One Earth Solar Farm

**Draft Statement of Common Ground with Nottinghamshire
County Council**

EN010159/APP/8.3

July 2025

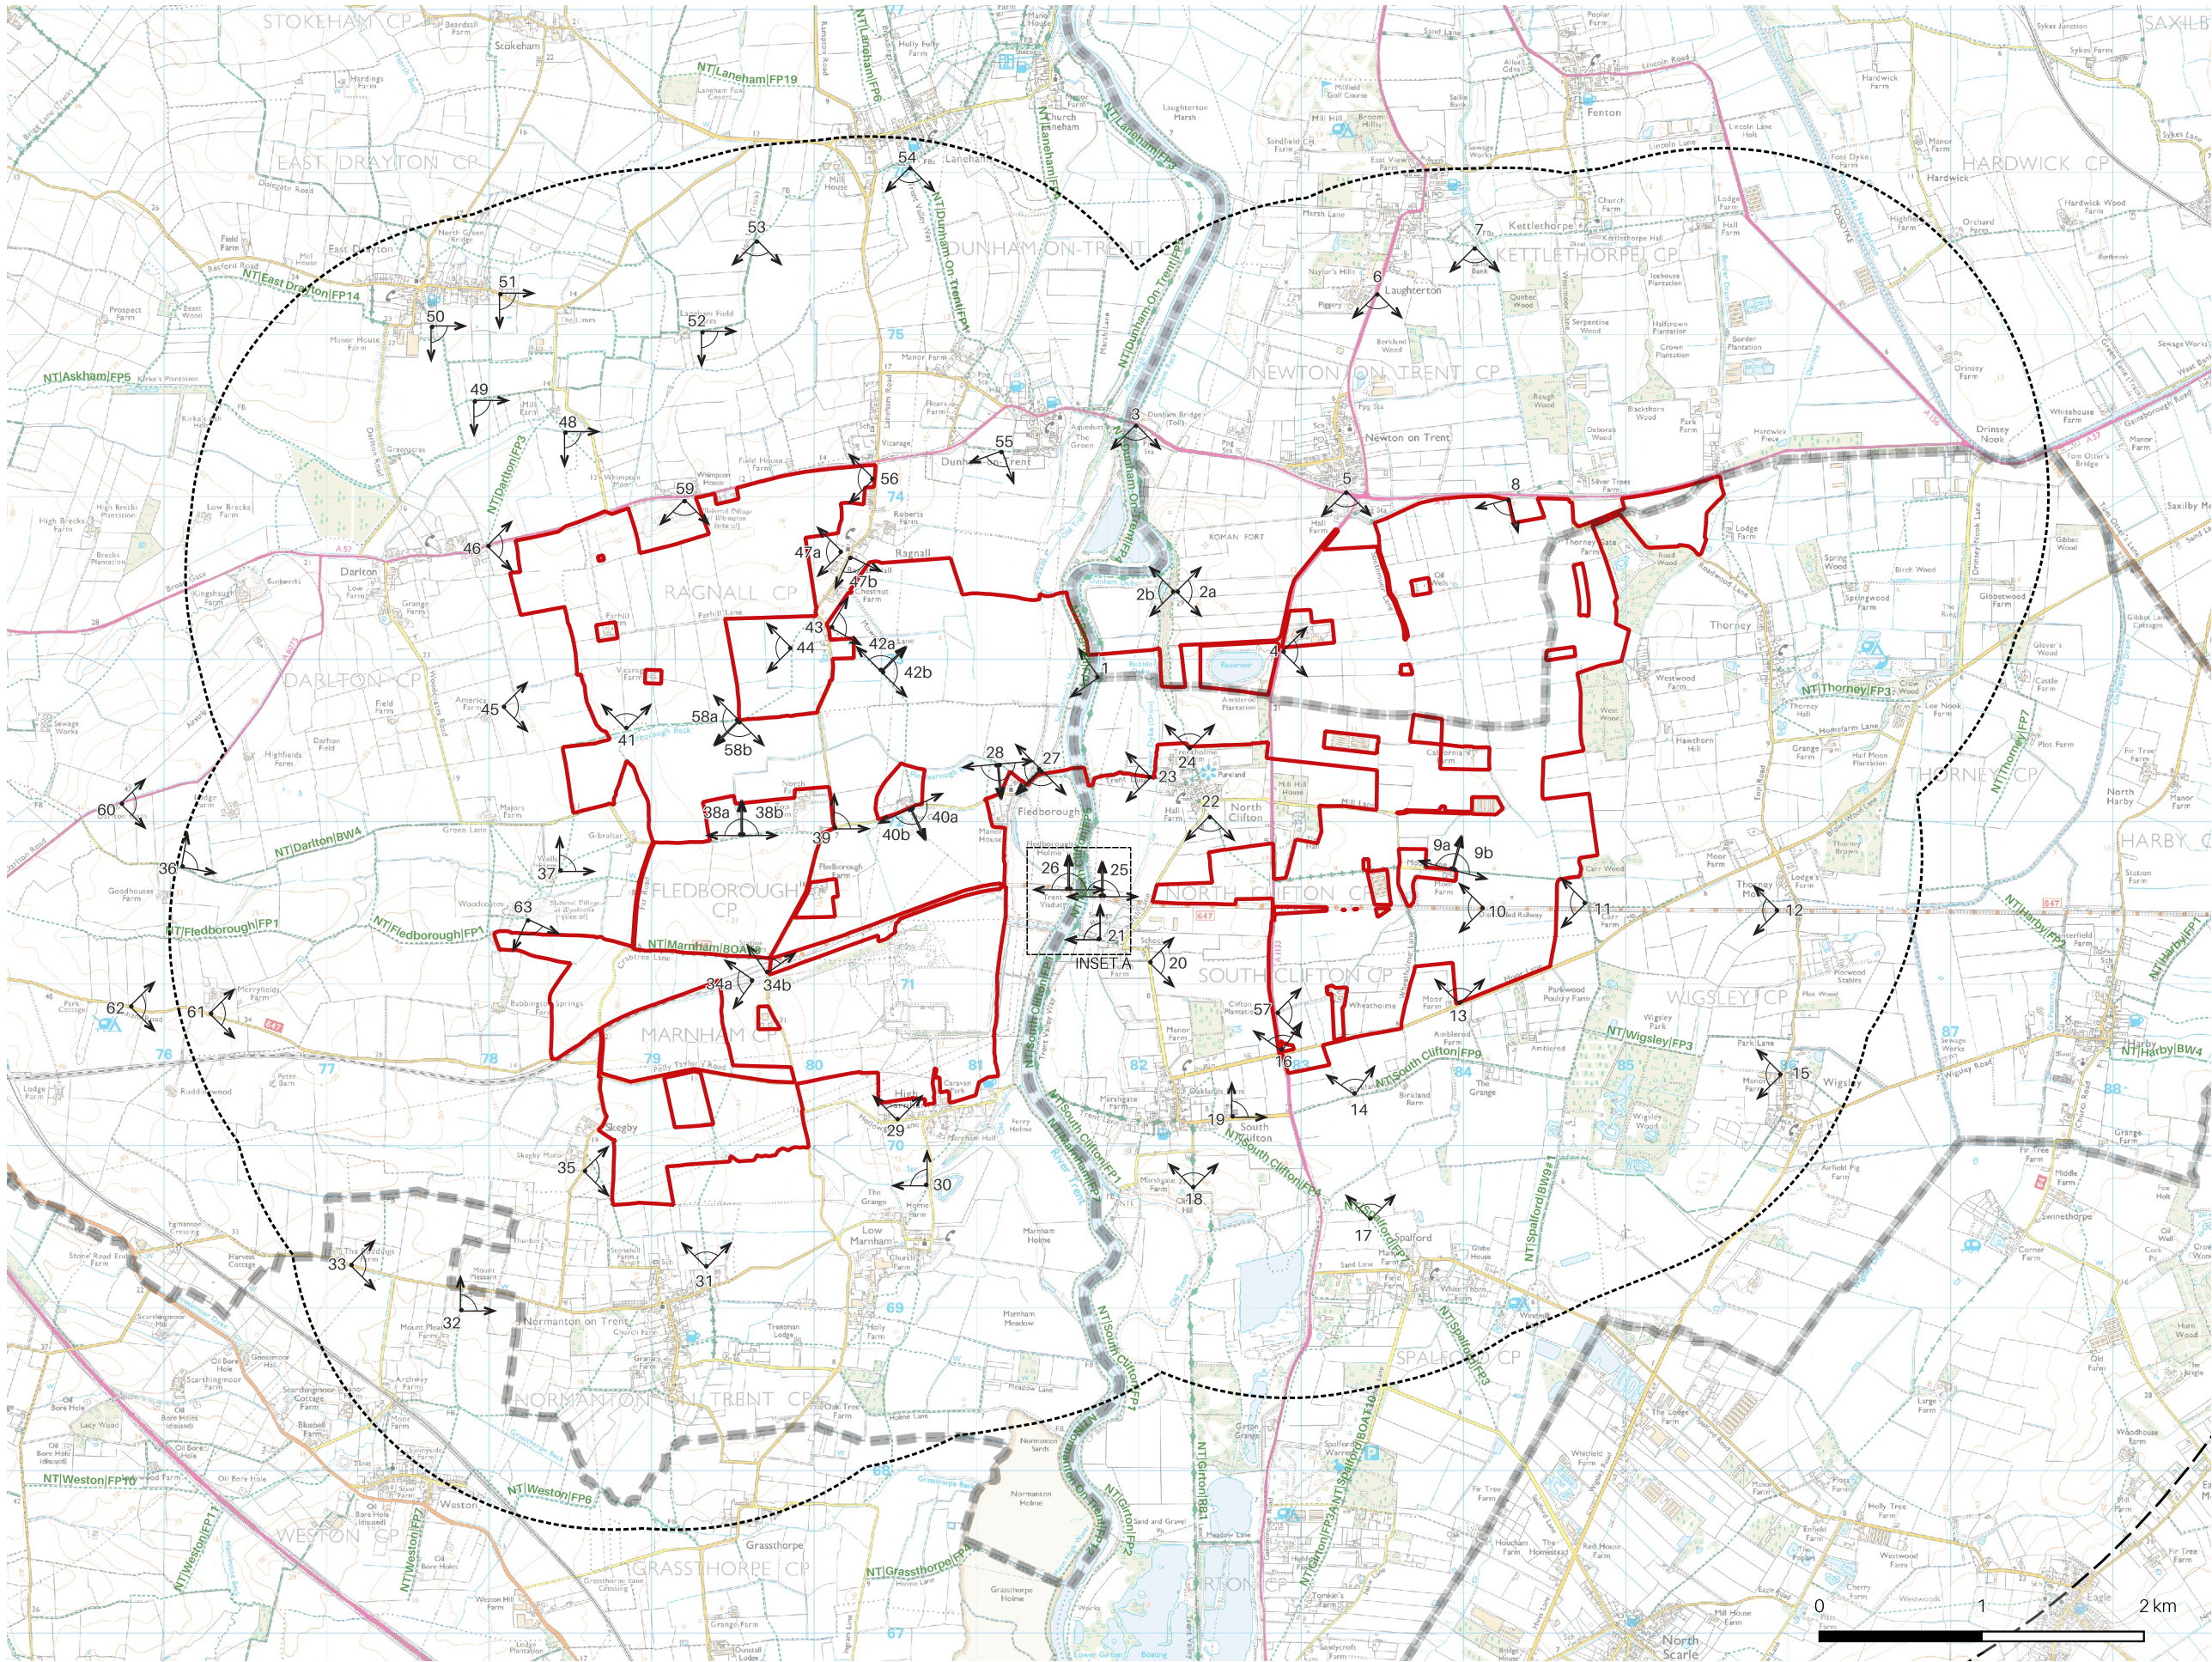
05-05	Scope of representative viewpoints	<p>The location of some of the representative viewpoints were</p>	<p>The scope of representative viewpoints is agreed.</p>	Agreed

questioned and additional viewpoints were suggested following review of the PEIR. No further comments or concerns on the scope of representative viewpoints have been raised.	The scope of representative viewpoints was updated in the LVIA ES Chapter to include for the suggested additions and refinements.	
05-06	Scope of photomontages	An additional Type 4 photomontage was suggested from Viewpoint 58 following review of the PEIR. No further comments or concerns on the scope of representative viewpoints have been raised.	The scope of photomontages is agreed. Further discussion was had between the applicant and the District Councils during the preparation of the LVIA ES Chapter regarding the scope of photomontages resulting in agreement that the number and distribution of locations is sufficient.	Agreed
05-07	Assessment assumptions and limitations	The approach to solar panel replacement during the operation phase was questioned following review of the PEIR. No further comments or concerns on the assumptions and limitations have been raised.	The assumptions and limitations of the LVIA are agreed. Additional detail was provided in the LVIA ES Chapter to include a reasonable worst-case scenario with regard to solar panel replacement during the year 15 operational assessment scenario.	Agreed
